Subject: RE: BN/50/20/PL (Condition 13) - Pre-commencement site meeting (Tree Protection Measures)

Mark Warwick
Tree Officer, Greenspace Team

Tree Retention Protection Plan

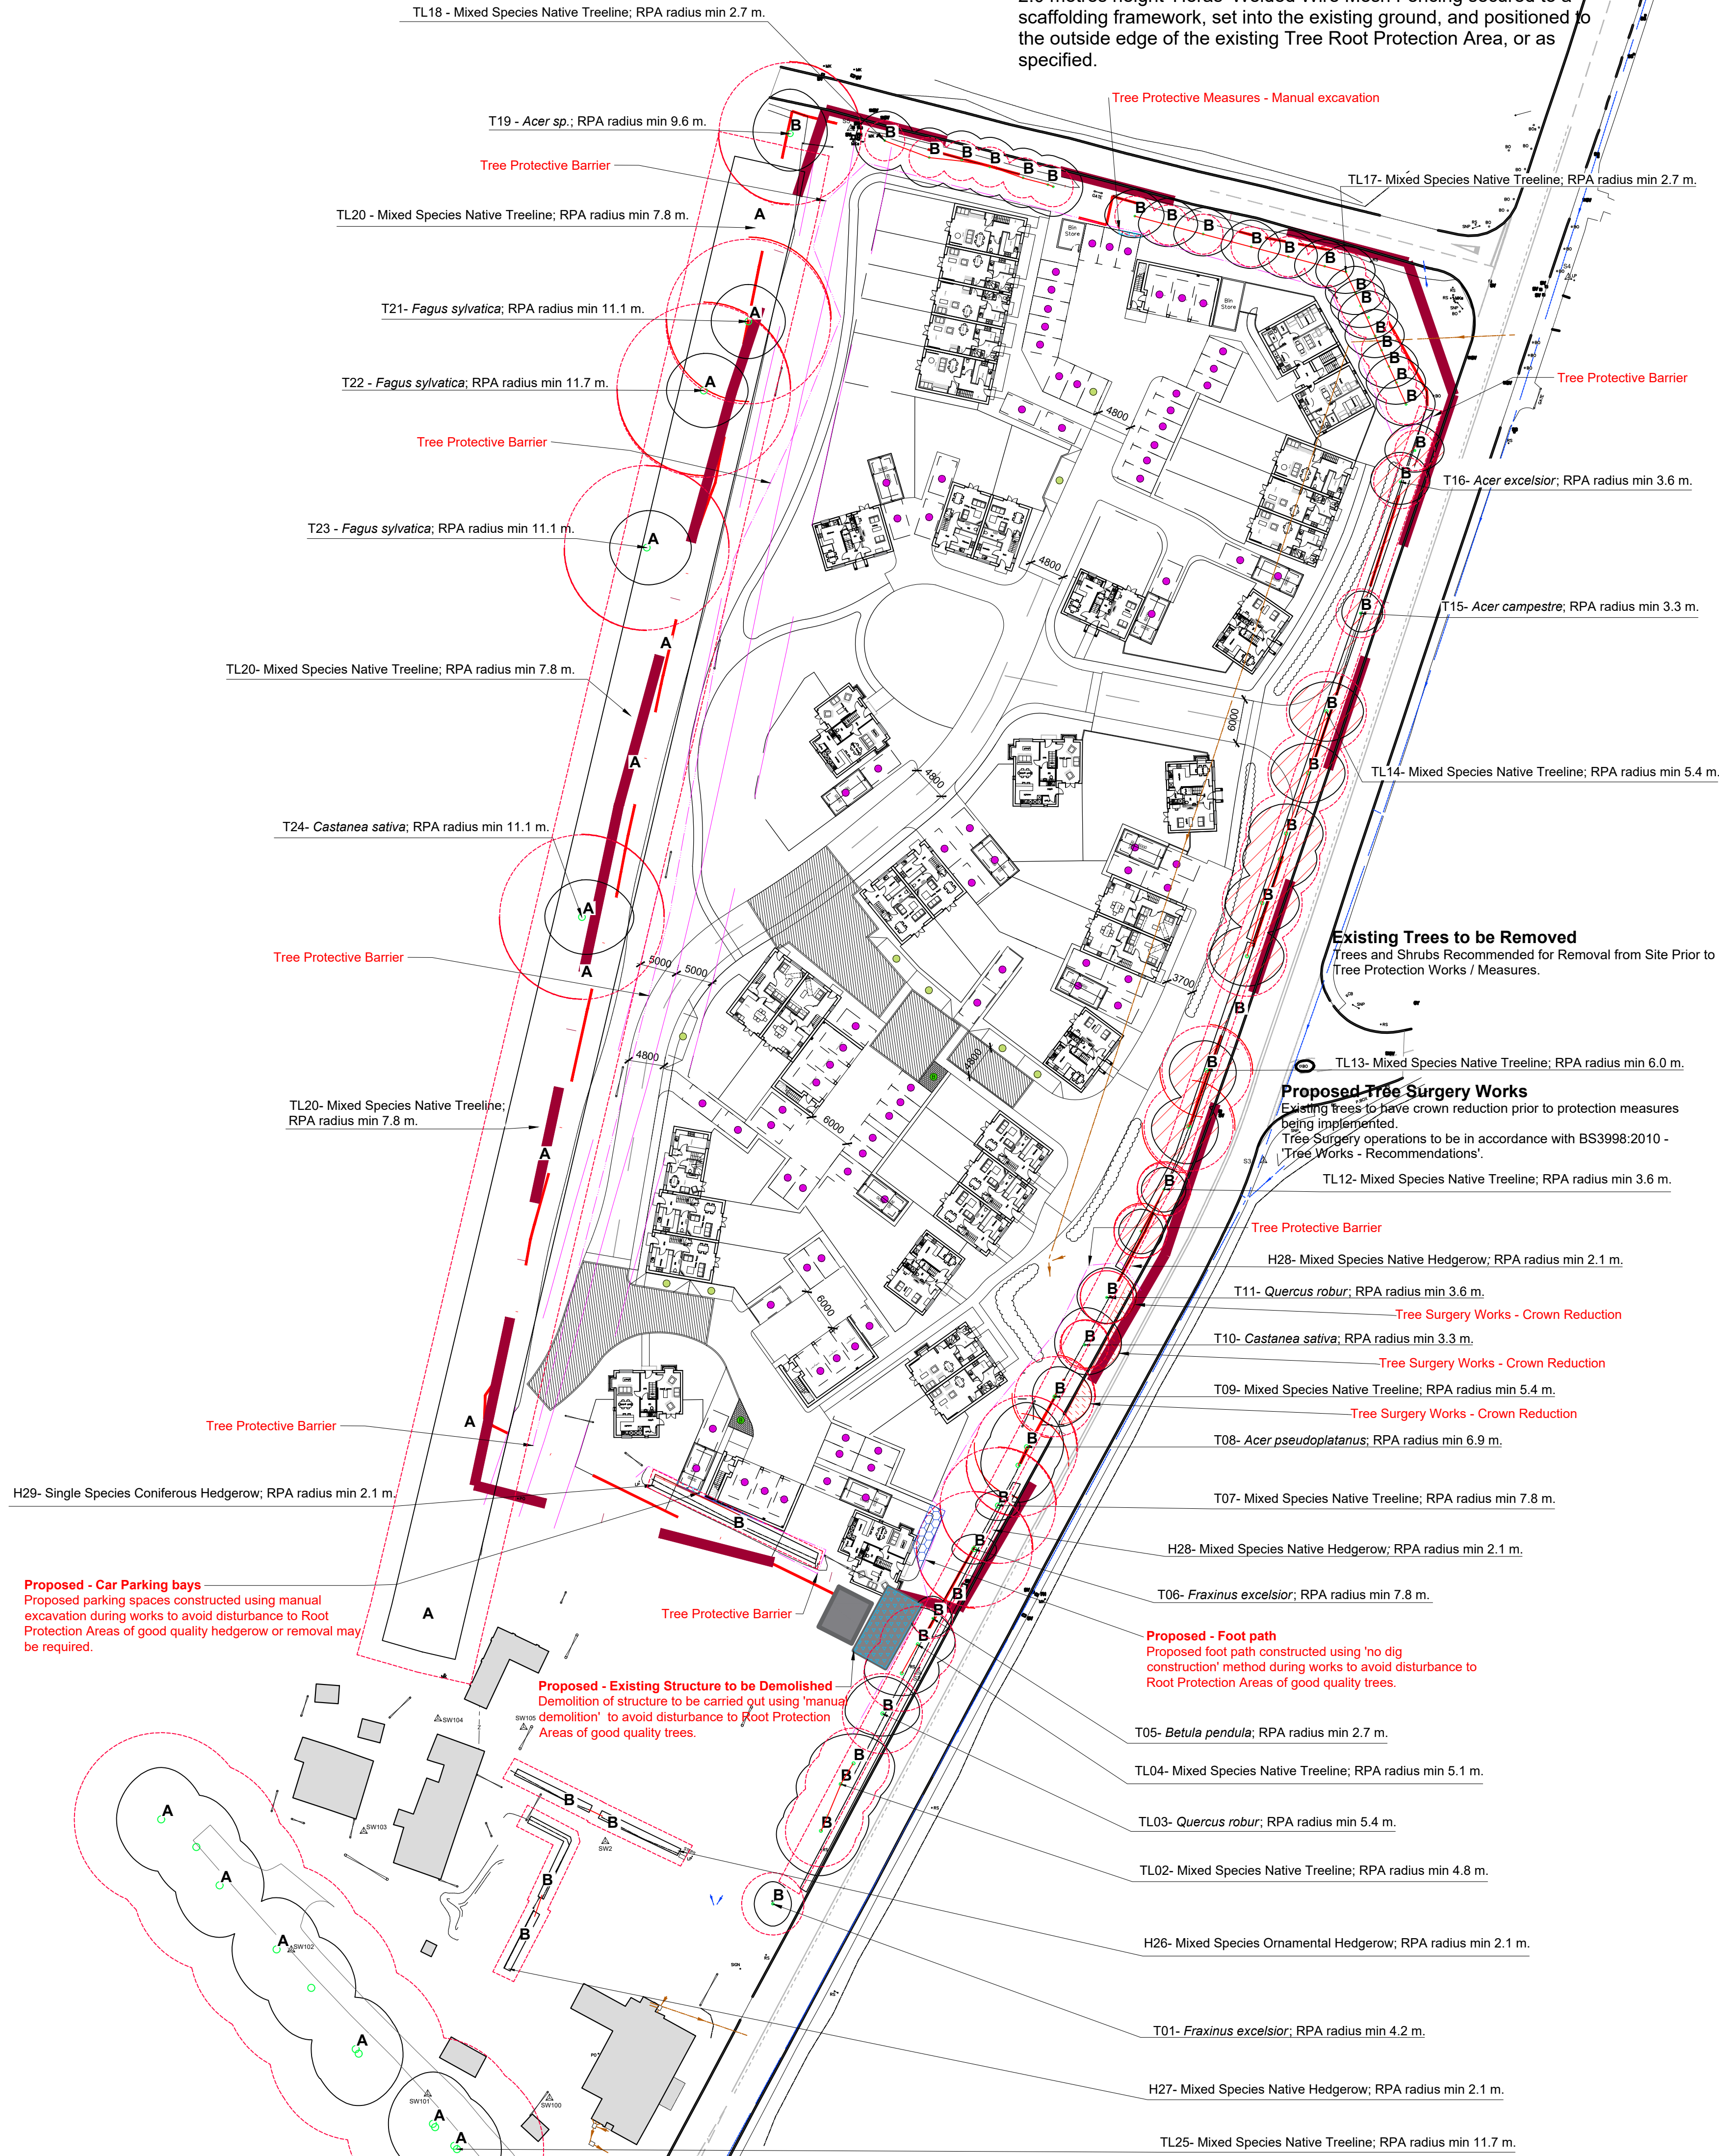
I can report that the vast majority of Tree Protection Fencing is correctly located and installed 'fit for purpose', although there are a number of significant anomalies which will need to be resolved prior to commencement and to ensure adherence with the approved Arboricultural Impact Assessment and Method Statement. Described as follows:

- Fence line is open at NW corner of site.
- Fence line is open at existing 5-bar gated access from Fontwell Avenue.
- All-weather notices attached to HERAS panels are scarce and their message lacks authority, appearing more to be an advertisement for the tree work contractor who provided them. The following important wording is missing – '*Construction Exclusion Zone – NO ACCESS*'.
- There are no day-glo ribbons attached to the top of the barrier, to ensure the fencing is clearly visible during the works.
